CITY OF ALBUQUERQUE

December 15, 2022

Re: Residence INN & Food Hall
1111 Central Ave. NE
Traffic Circulation Layout
Architect's Stamp 11-09-22 (K15-D034D)

11 TYPICAL MOTORCYCLE PARKING STALL

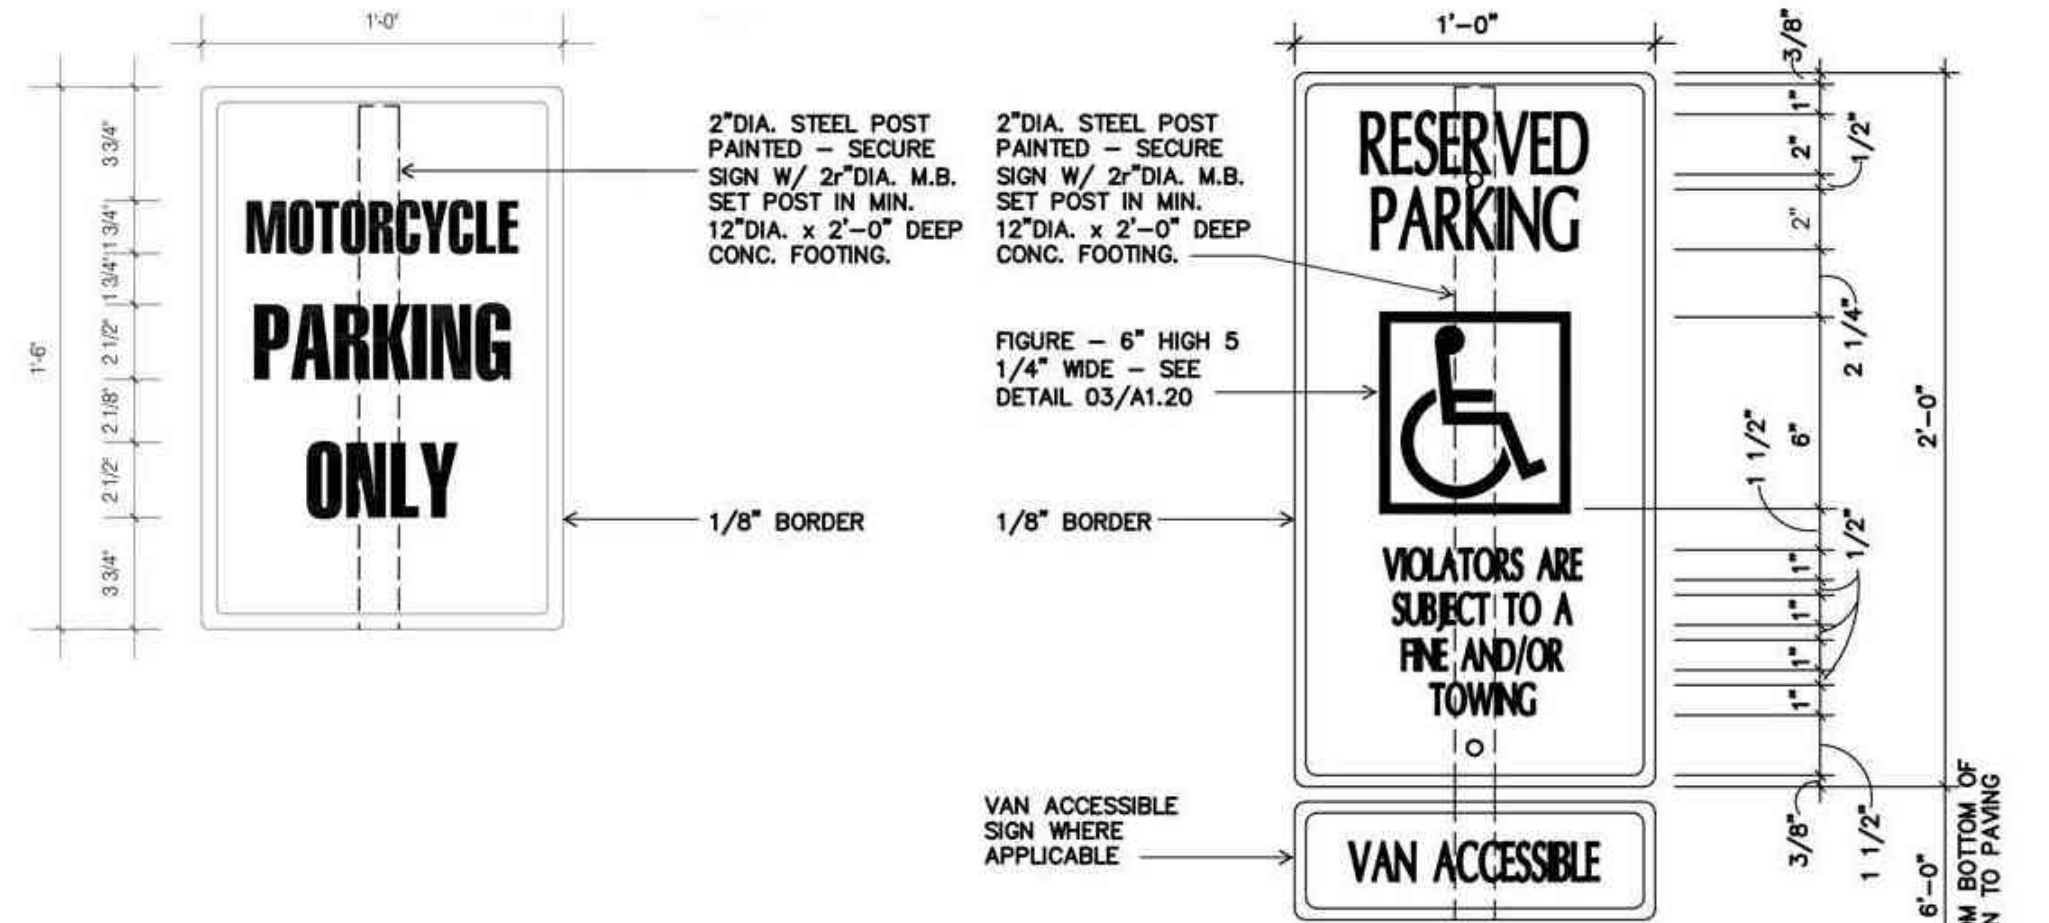
9. The pavement marking "MC" should be shown in the opposite direction for motorcycles entering the parking space.
10. Refuse vehicle maneuvering shall be contained on-site. The refuse vehicle shall not back into the public right of way. provide a copy of refuse approval.

05 TYPICAL ACCESSIBLE PARKING STALL

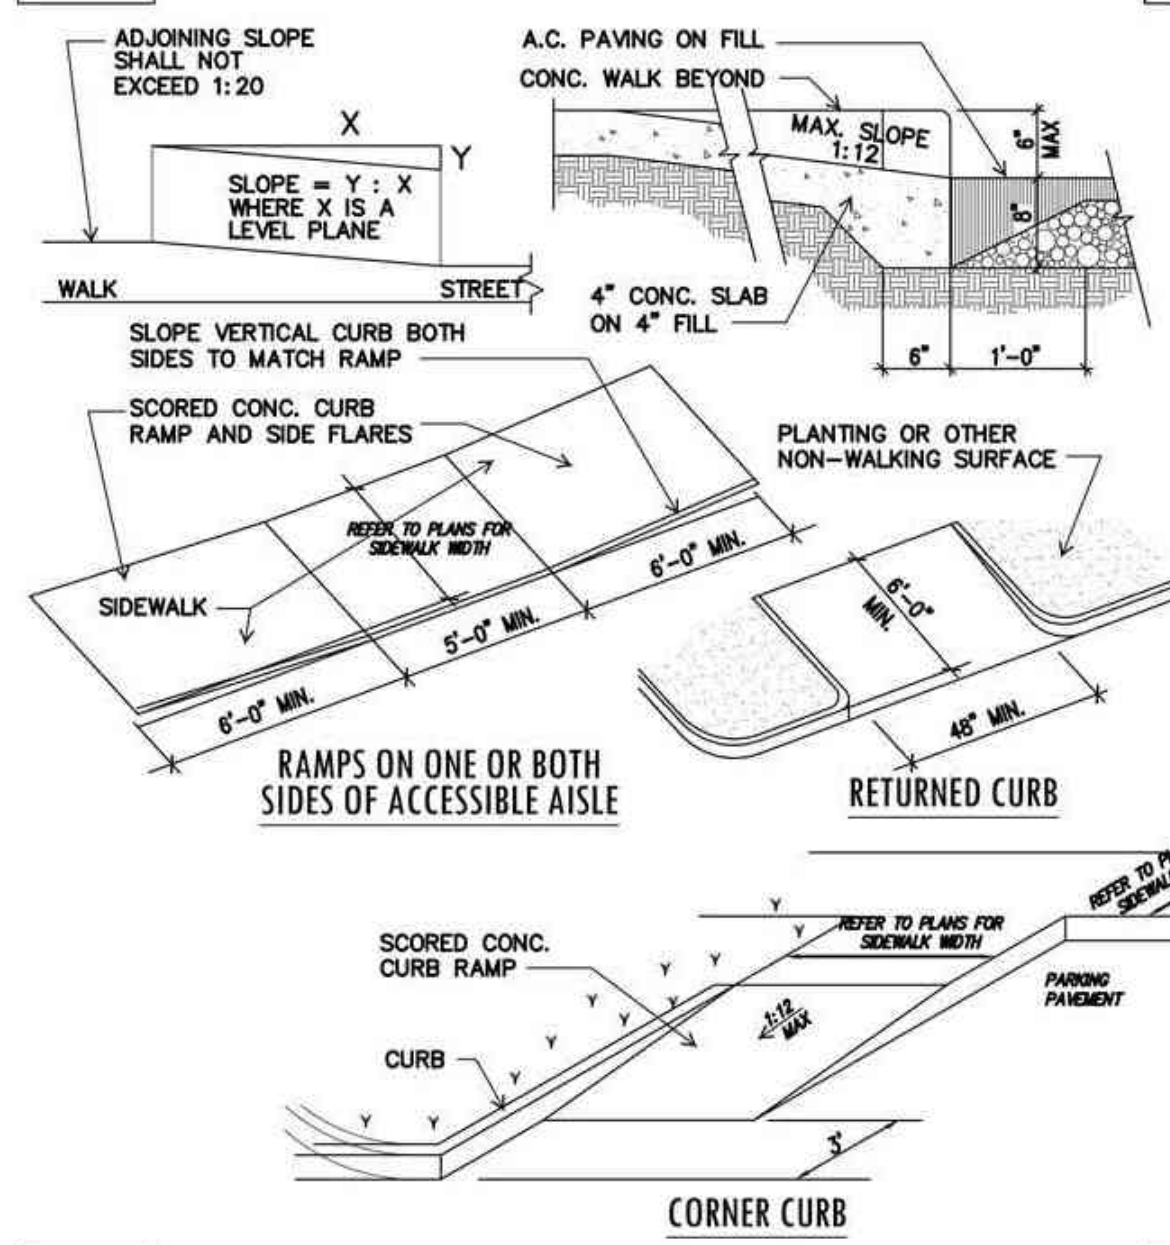
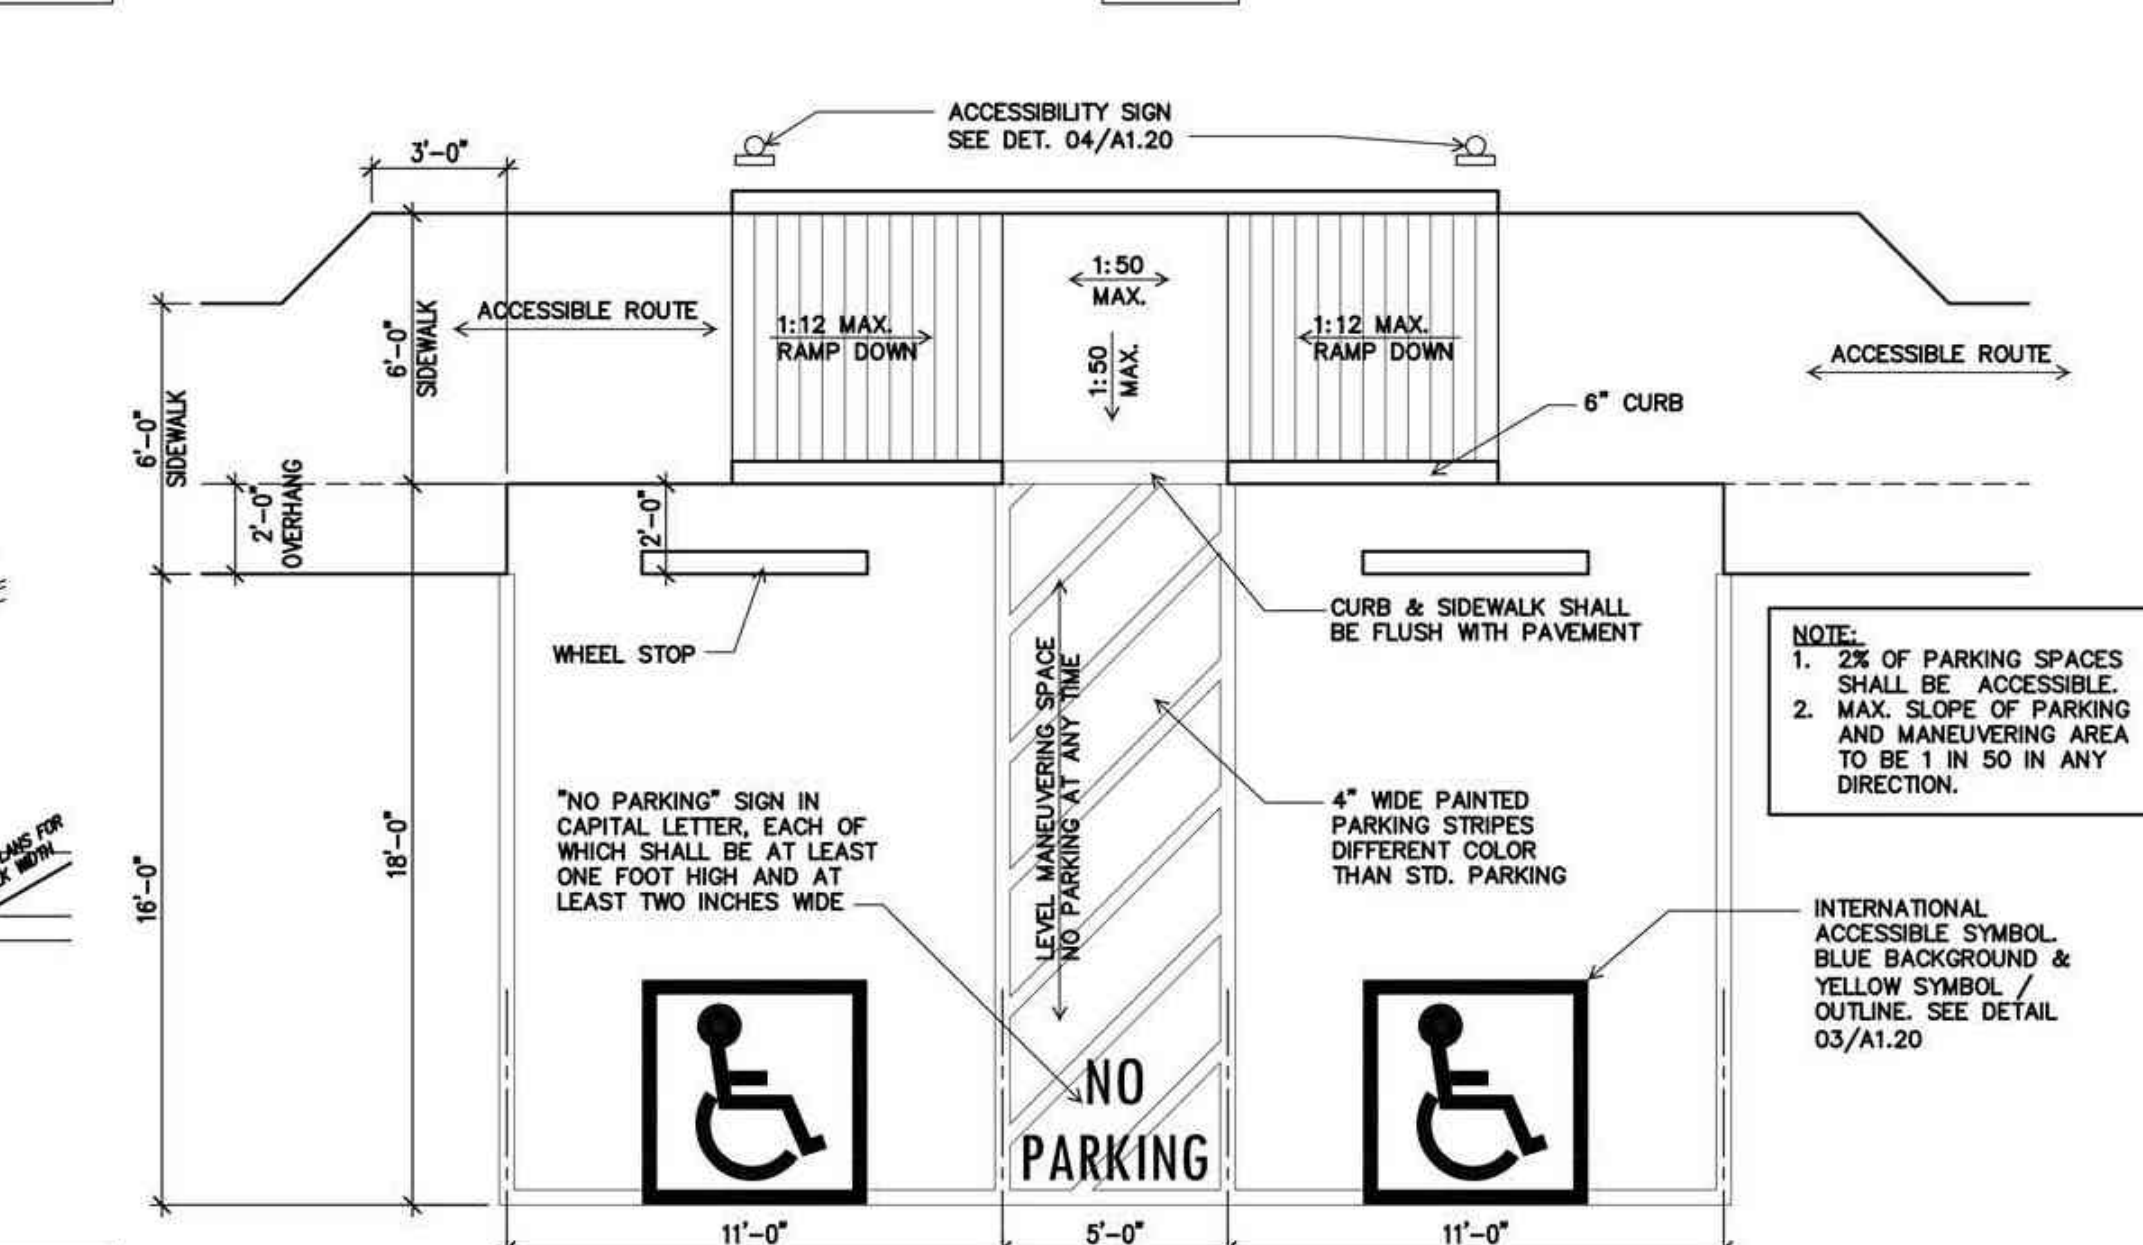
7. Provide design details for the parking entry (provide the width, radius, and ADA ramps details).
8. Sheet details is showing 6' pathway from the ADA aisle to the building entrance, but site plan sheet showing 5'. Please address this concern, and note that 6' ADA pathway is required from each ADA aisle to the building entrance.
